**Crystal Park Site 104, Walton/Howell Residence, CP-18-005**

Please accept the following comments from El Paso County Public Health regarding the project referenced above:

SITE PLAN

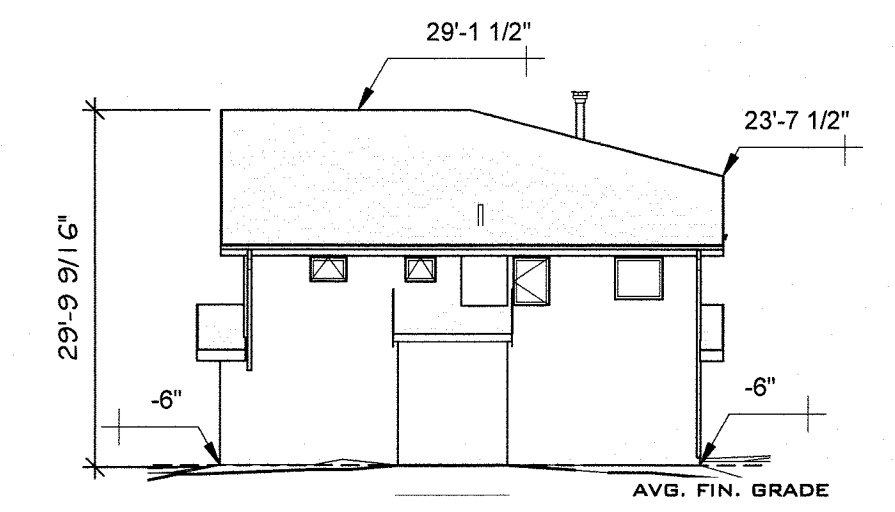
- **Crystal Park Site 104, 530 Sunrise Peak, is a residential development site that will be served water by an individual private well and wastewater will be treated by an on-site wastewater treatment system (OWTS).**
- **The site development plan shows the areas for both the primary and secondary soil treatment area (STA) locations. A New Onsite Wastewater Treatment System (OWTS) Permit was issued by El Paso County Public Health to the property owners in November, 2017. The OWTS must meet all current El Paso County Public Health OWTS Regulations.**
- **Radon resistant construction building techniques/practices are encouraged to be used in this area. The EPA has determined that Colorado, and the El Paso County area have potentially higher radon levels than most other areas of the country.**
